2.2 Scheme Changes Update

Proposed Elevations - East

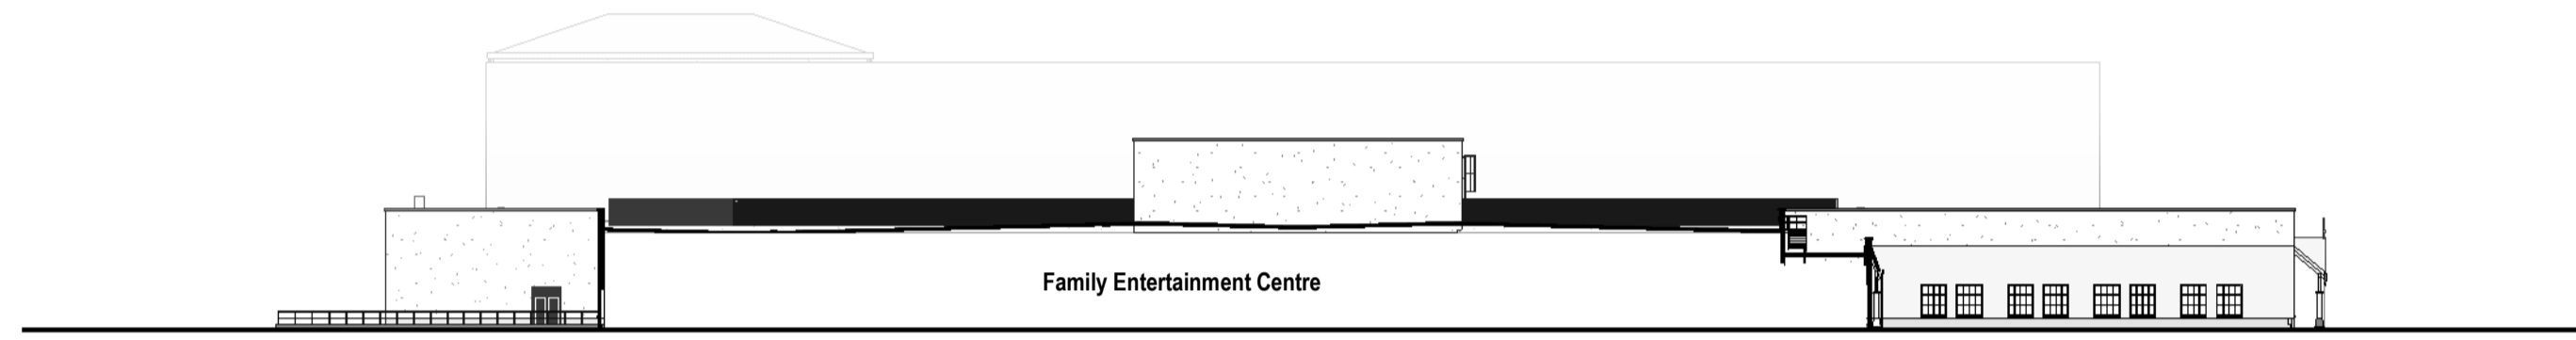
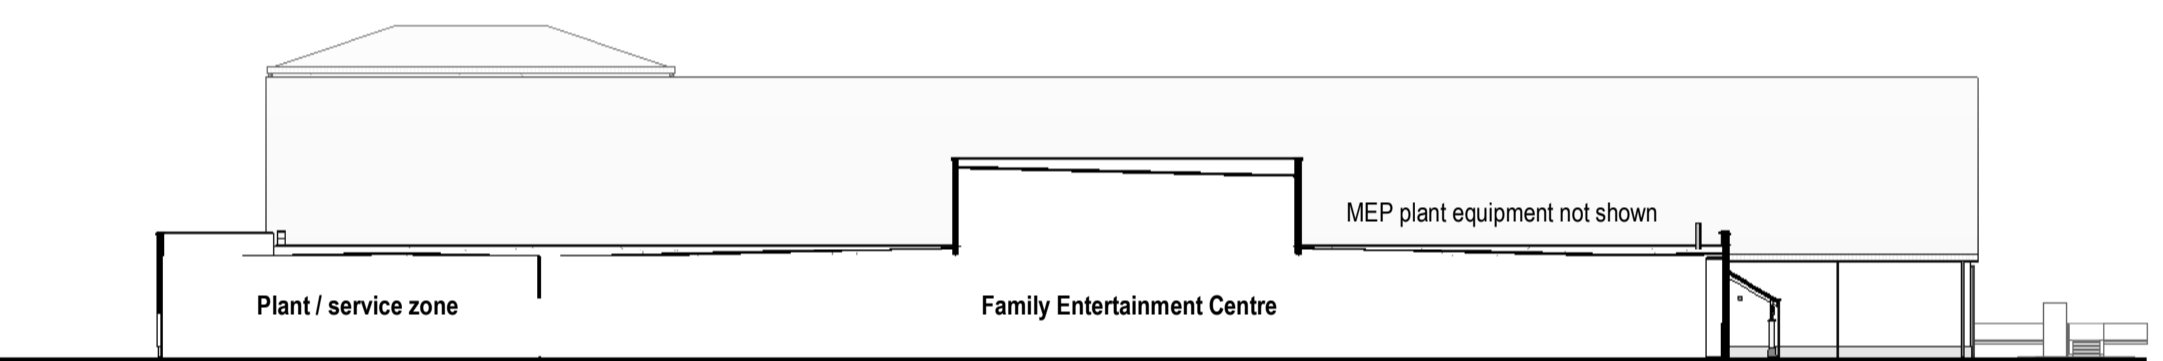
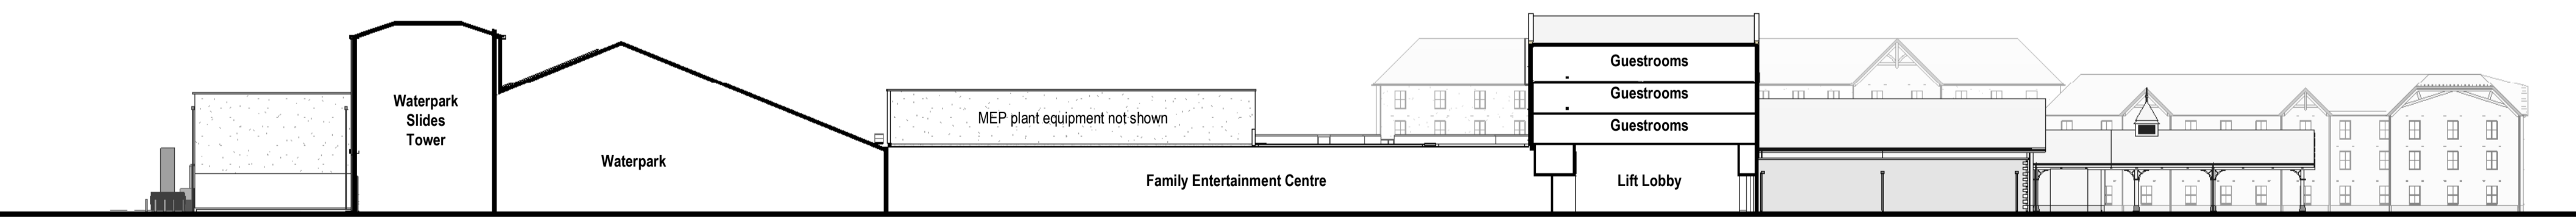
- ① Change from stone to buff brick to back of house areas of waterpark building
- ② Change to buff brick from blue brick material
- ③ Minor width increase to roof access platform
- ④ Introduce rain water pipe to corner of building

- 1. Introduction of Ventilation grilles above all guestroom windows

- ① Introduction of Ventilation grilles above all guestroom windows
- ② Reposition slot windows to eaves.
- ③ Re align windows above porte cochere

Proposed Elevations - West

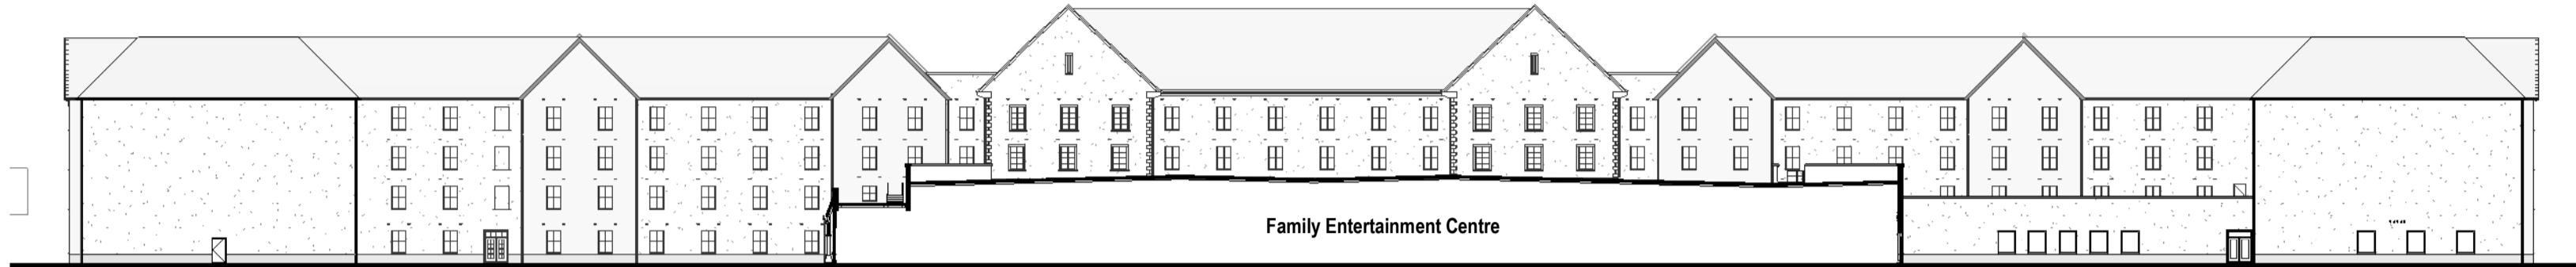
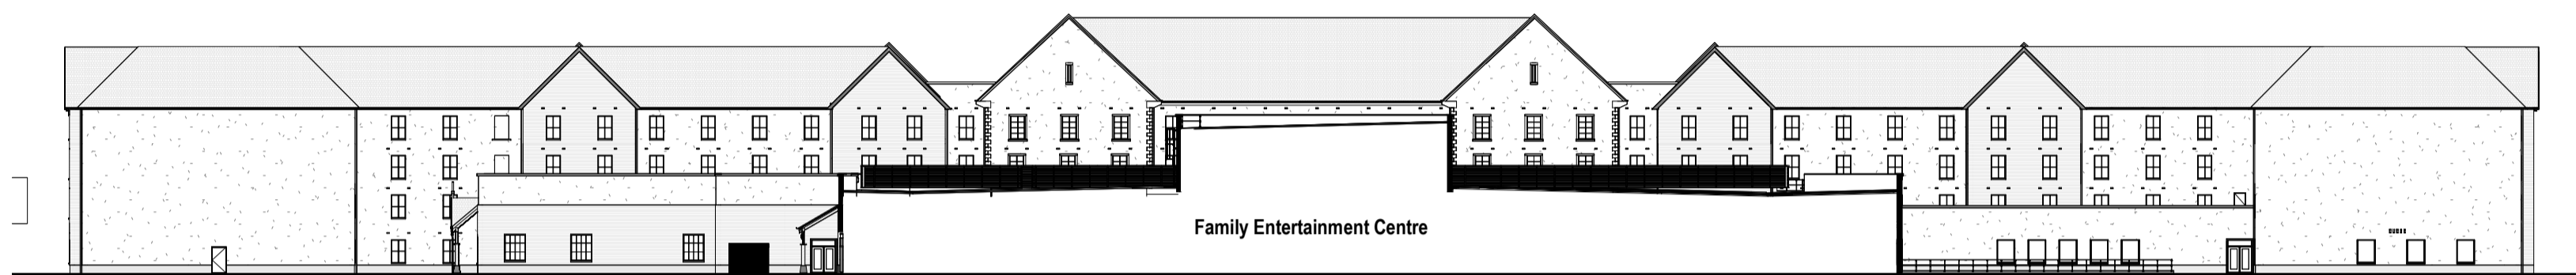
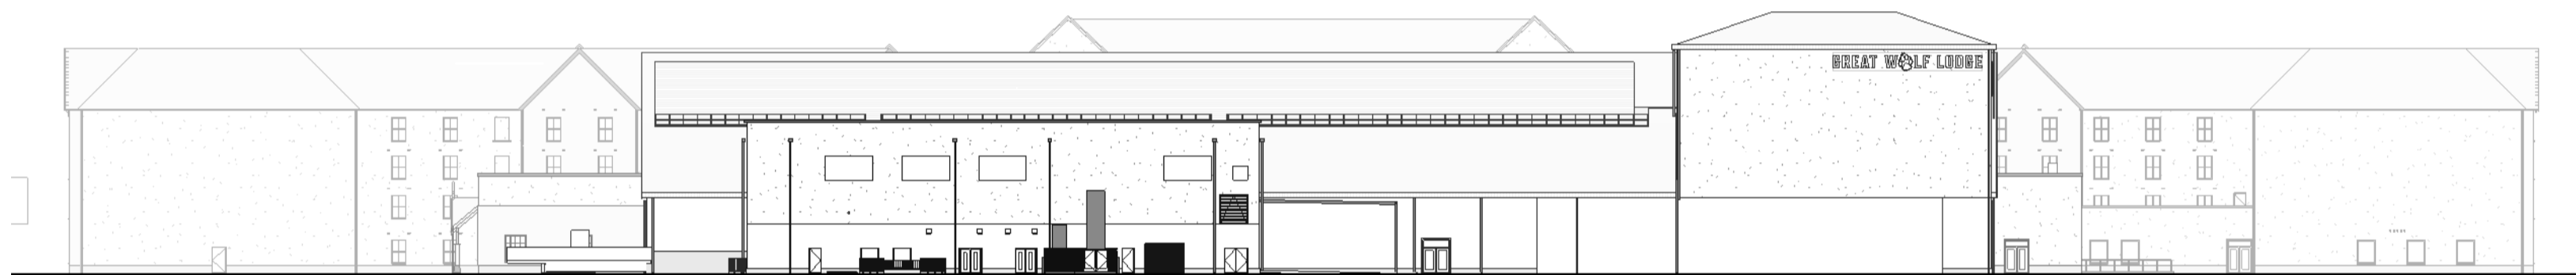
- ① Introduction of Ventilation grilles above all guestroom windows
- ② Change of rear of hotel from stone to timber with timber surrounds and metal sills
- ③ Reduction of brick plinth to back of house areas of water building / change to buff brick from blue brick material
